COMMENTS

Inspection Record

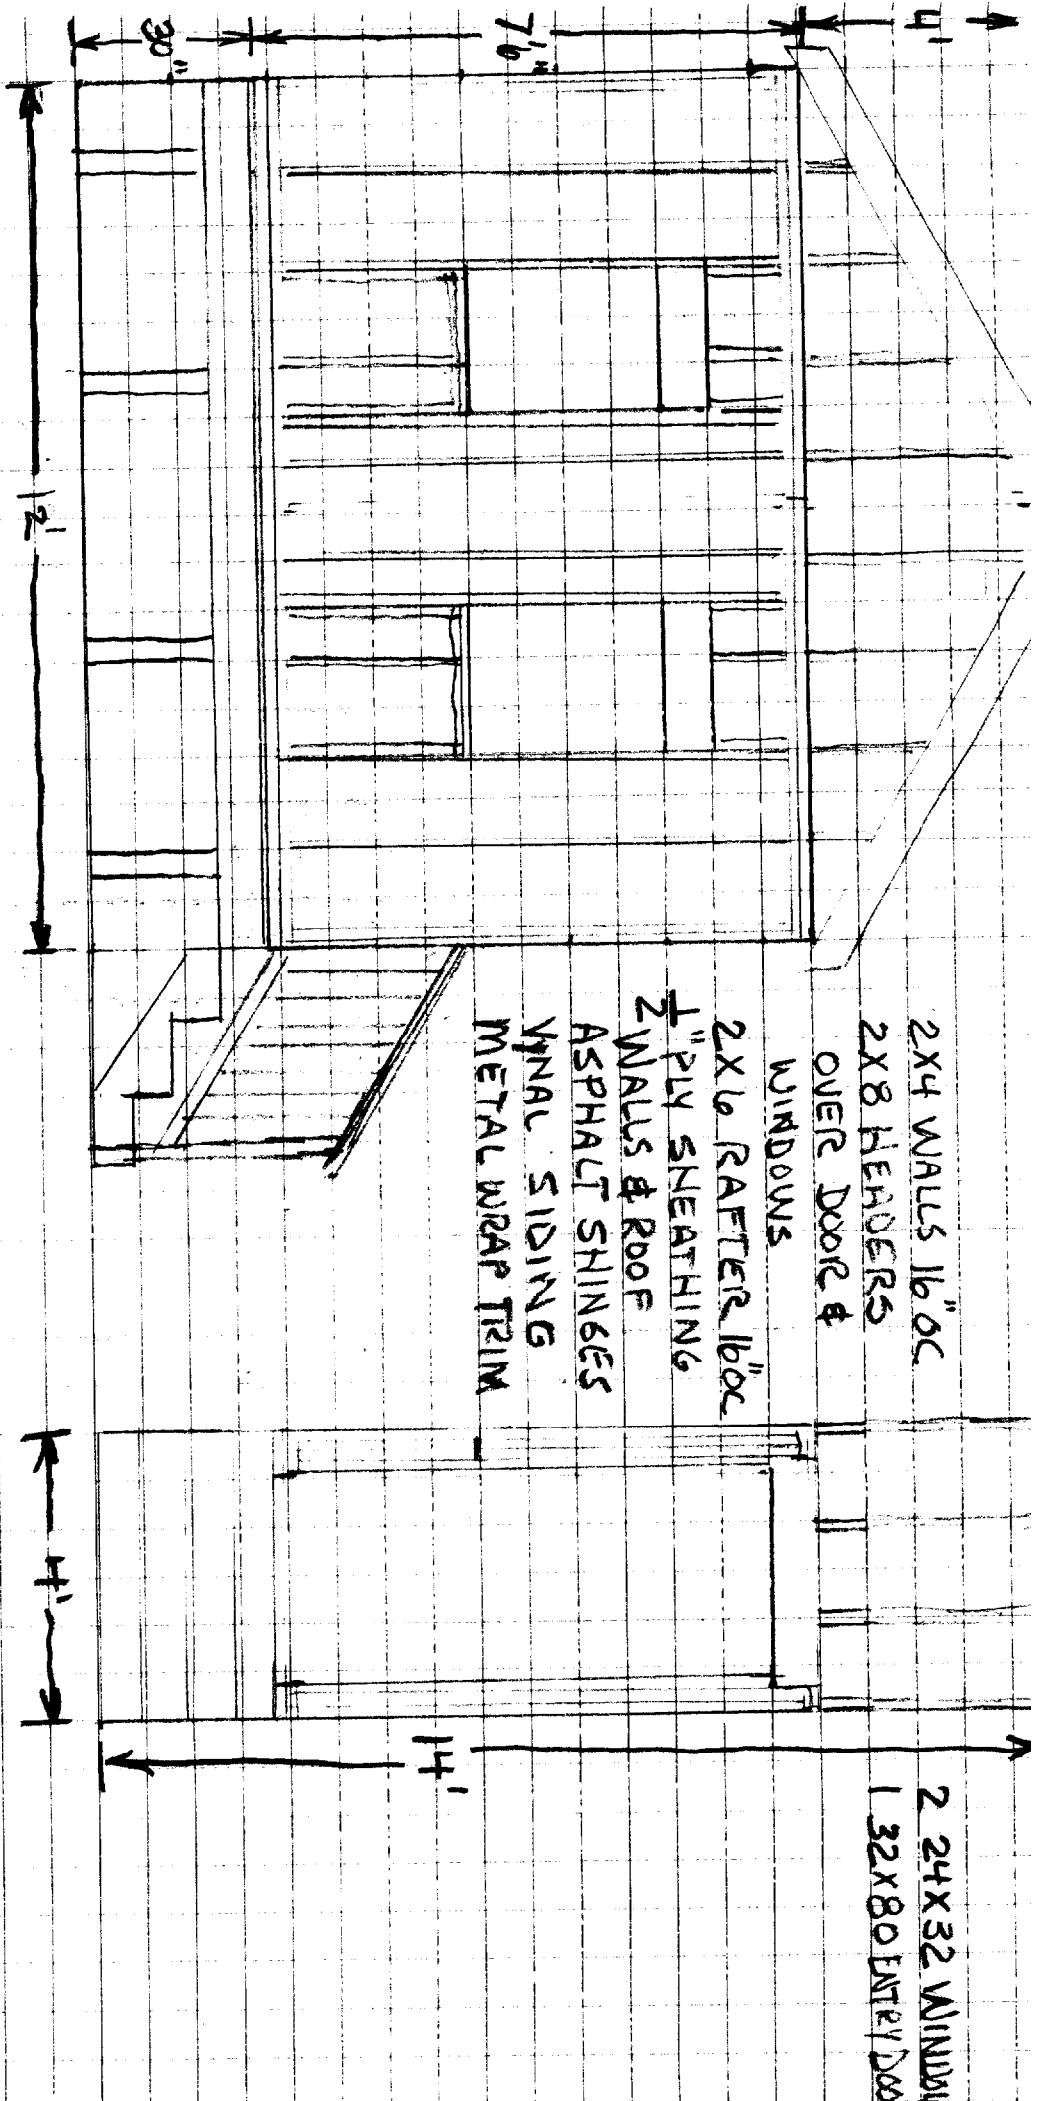
12/16/99 Porch finished - rail heights + distance openings OK - 2 steps with one at 11^{1/4} inch rise - no handrails or guardrails in place. - 20 inch height from ground surface to top of decking. Call owner or write memo
